Zoning Confirmation Report

312 Lisgar St

July 23, 2025

1 SITE PLAN
SP1 1:100

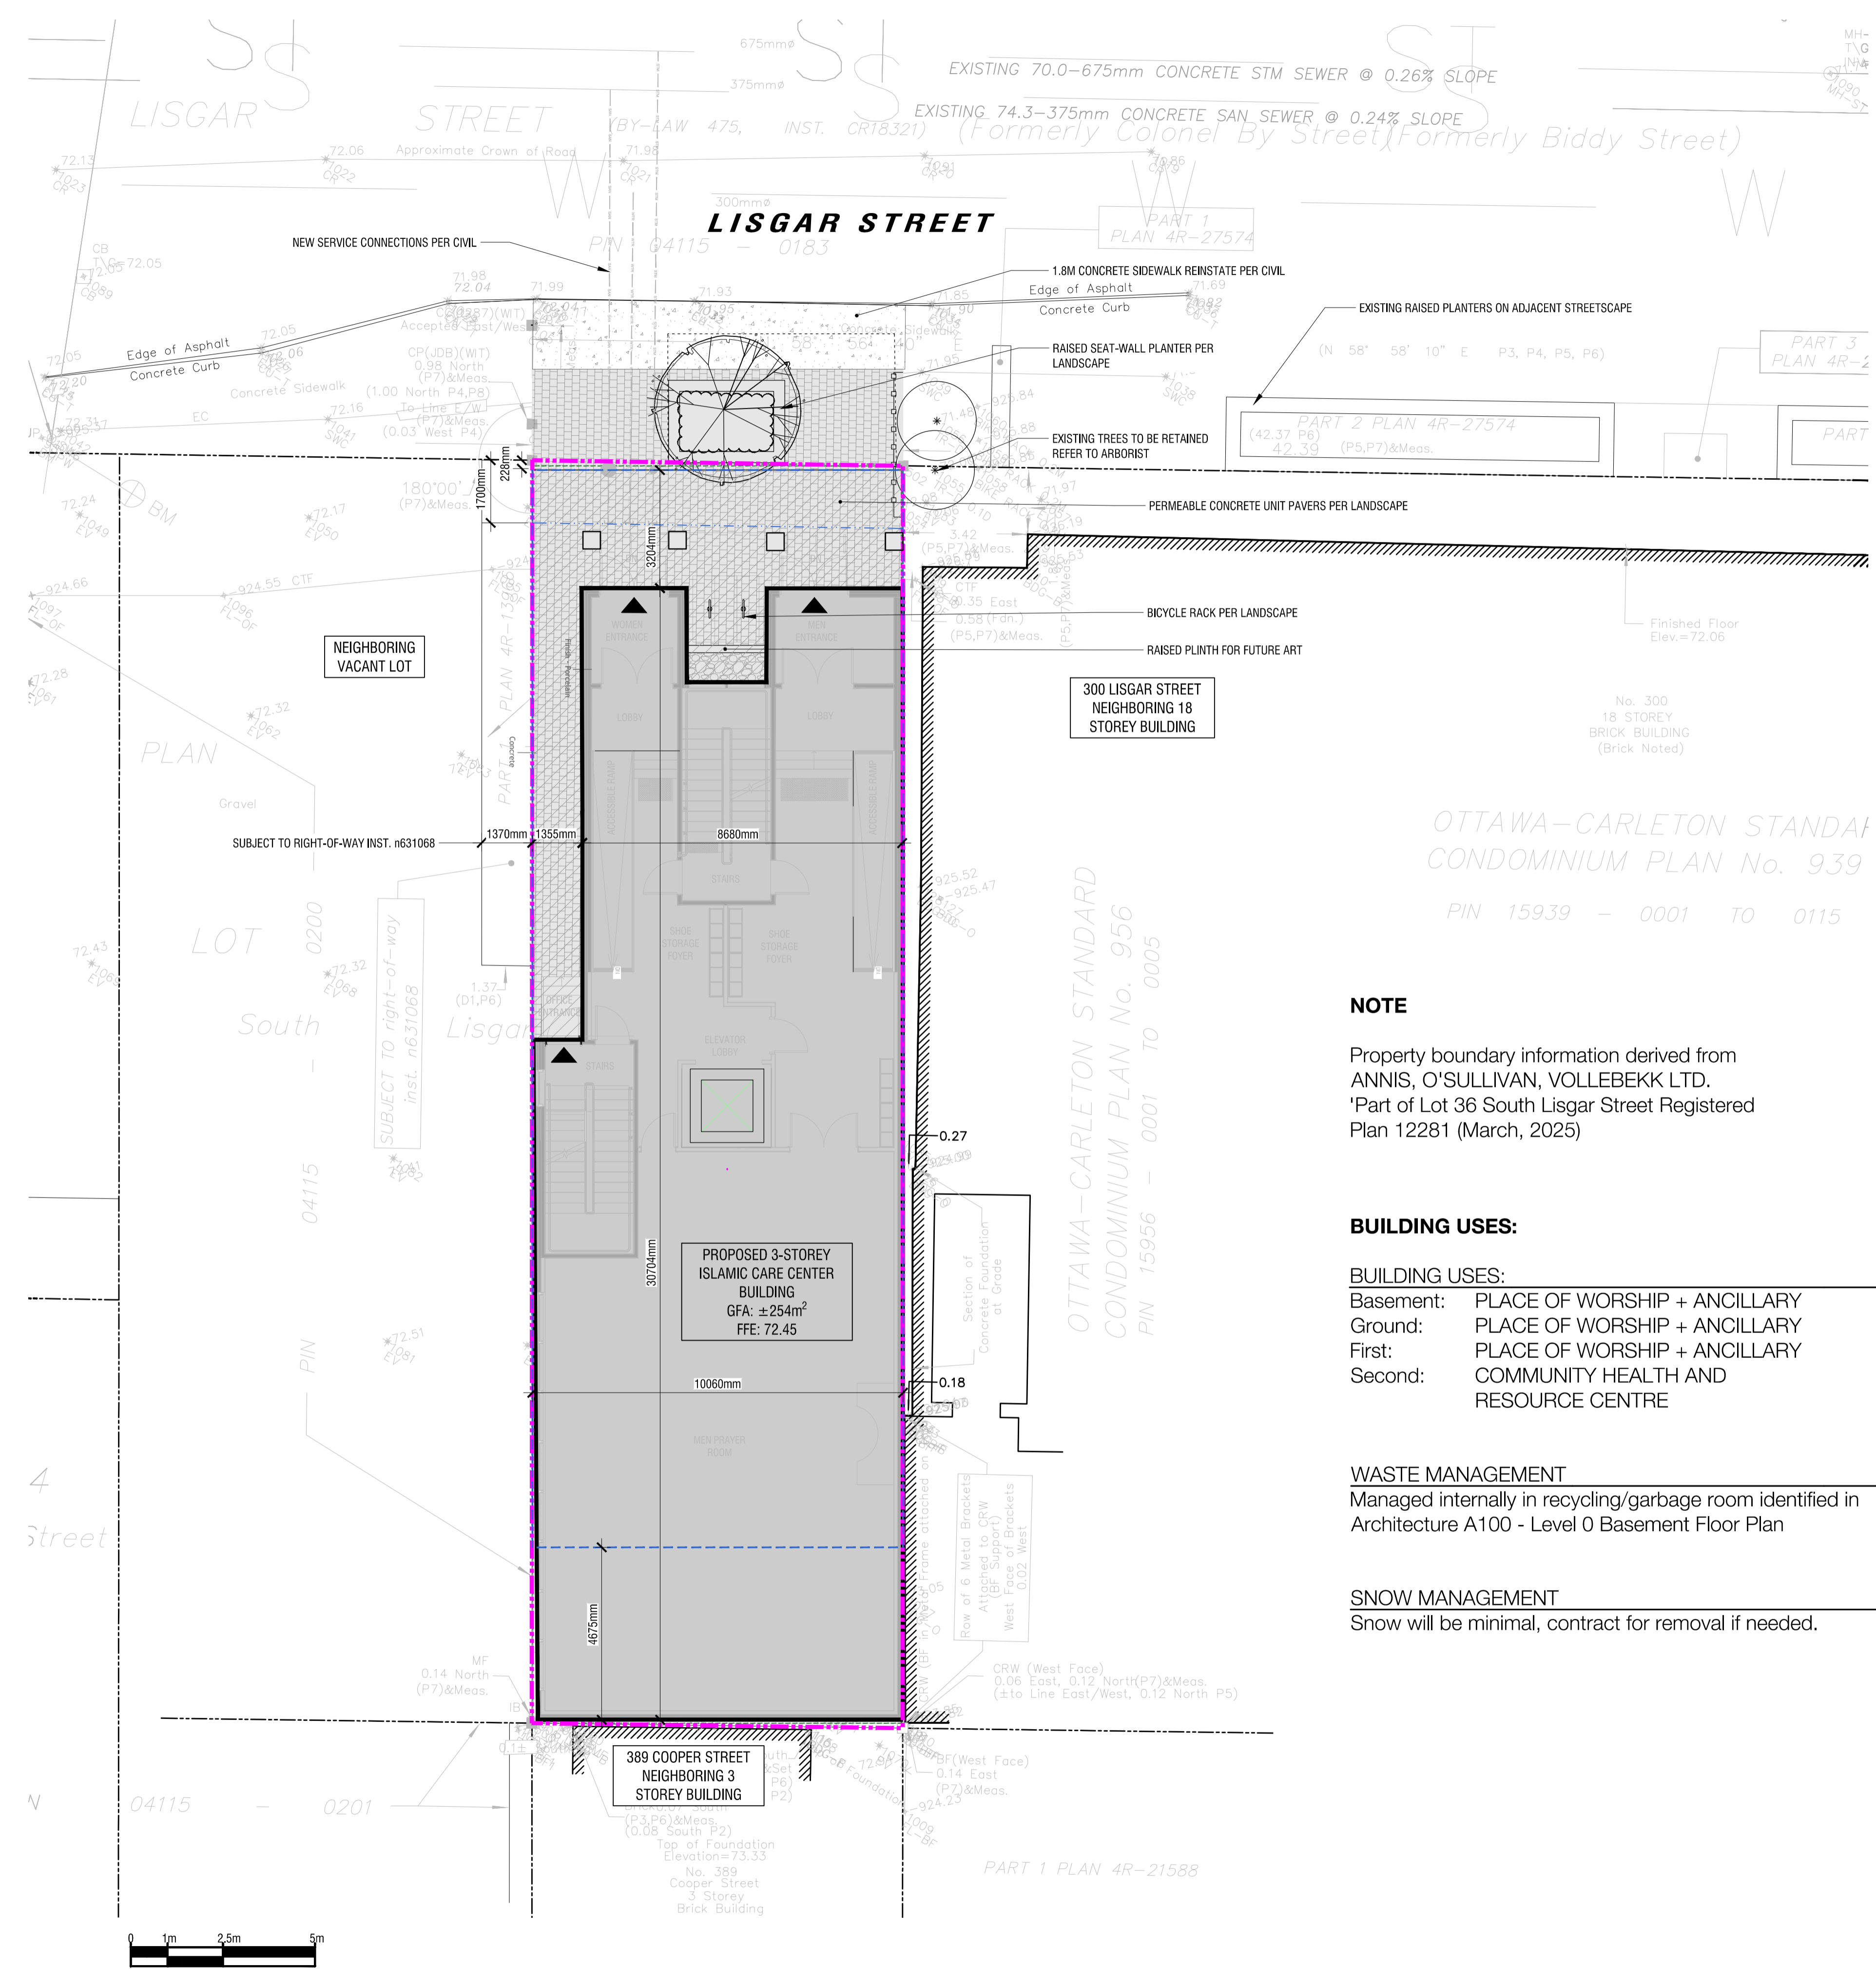
| B. Zoning Review | | | |
|---|--|---|-----------------|
| Front Yard Set Back Exception [1912] | 1.7m | 1.75m – Main Floor 0m – 2 nd Floor and above | N |

| Section | By-law Requirement | Requirement | Proposed |
|------------------|---------------------------|---|--|
| Exception [1912] | Front Yard Set Back | 1.7m | 1.75m – Main Floor 0m – 2 nd Floor and above |
